RESPONSE TO:

REP 3/037 Additional Viewpoints, and Document: 8.4.1.2 Addendum to Applicant's Comments on Relevant Representations - Part 2 Final Issue A April 2026 Planning Inspectorate Reference: EN020027 . Page 233 NG response to Earl Stonham Parish Council

Viewpoint 2.40: A1120, Forward Green (View Direction 212)

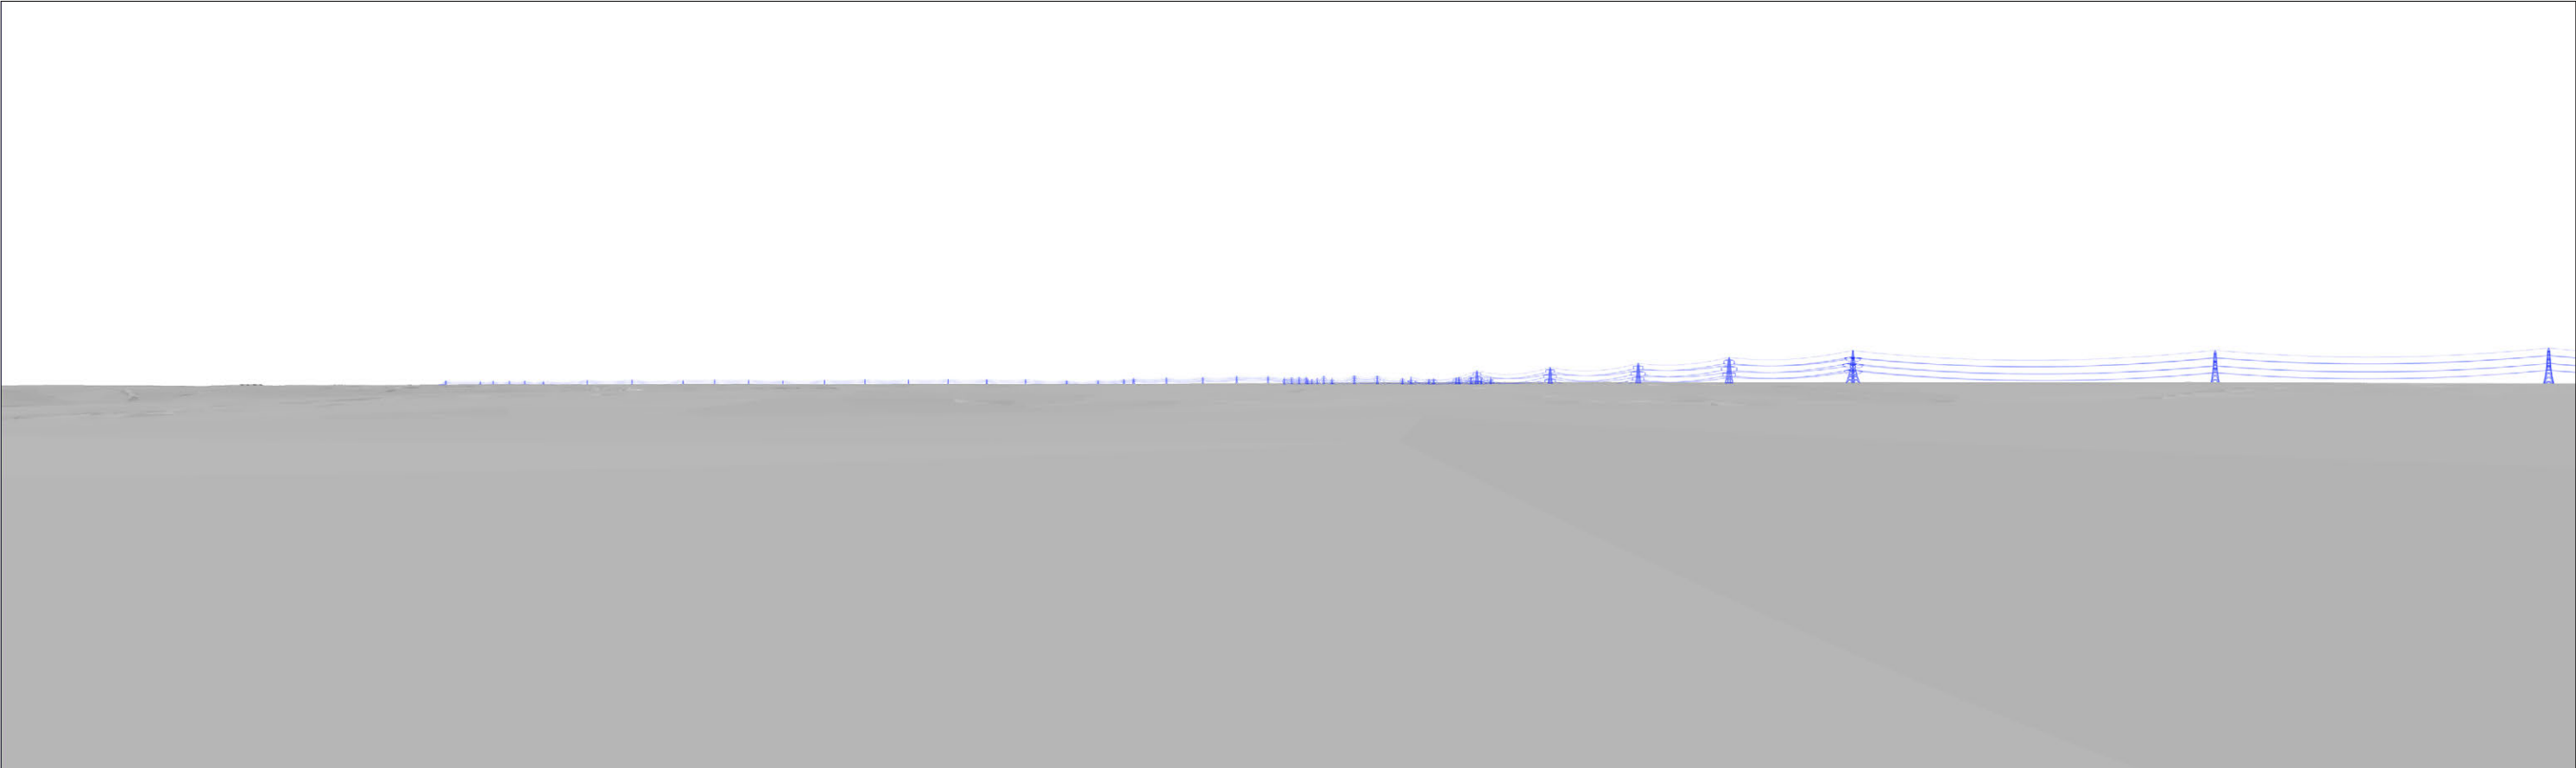
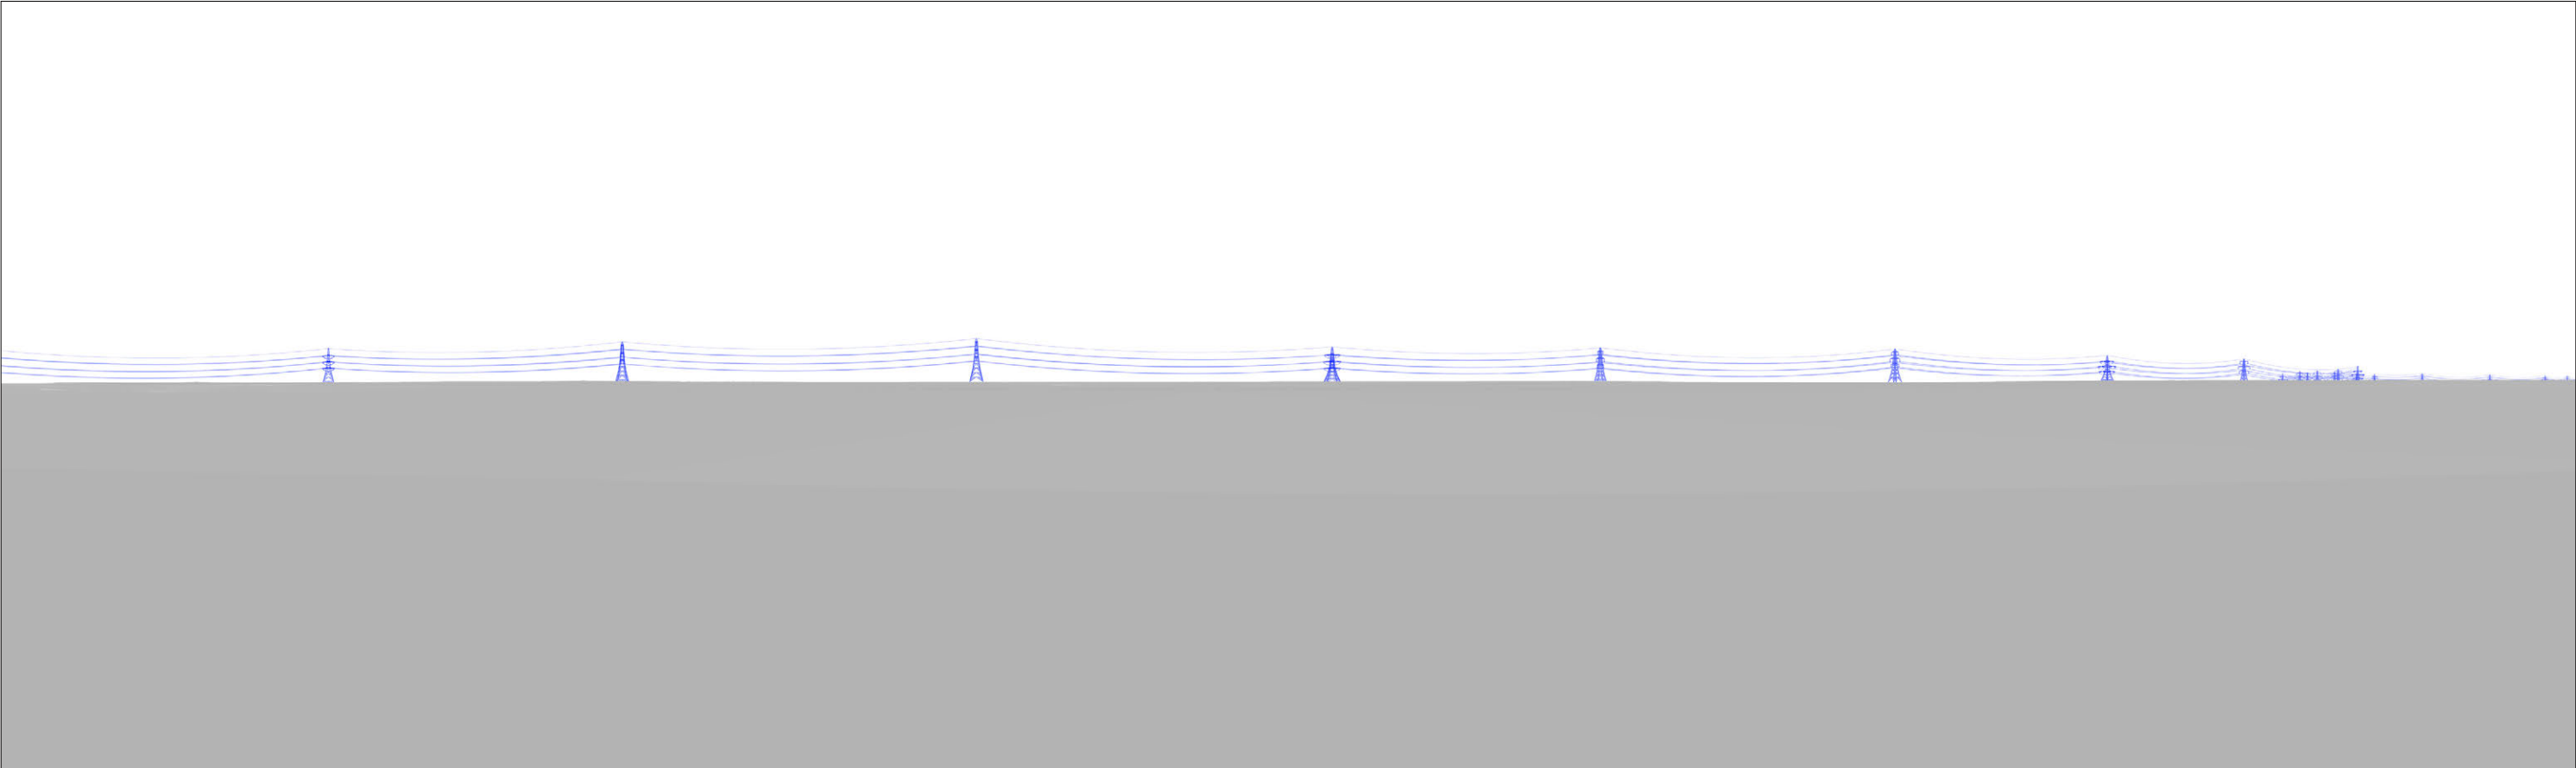
“Three viewpoints are located within the parish, presented in 6.13.A3 Environmental Statement Appendix 13.3 - Visual Baseline and Assessment - Part 2 of 4 [APP-230]. The effect on Viewpoint 2.40 A1120, Forward Green (pdf page 46) is assessed as minor and not significant (adverse).”

This viewpoint at Forward Green/A1120 understates the visual impact of the pylons. The viewpoint needs to be further west, near Wicks Lane and Earl Stonham Village Hall, from where the proposed power line and pylons will be much more visible.
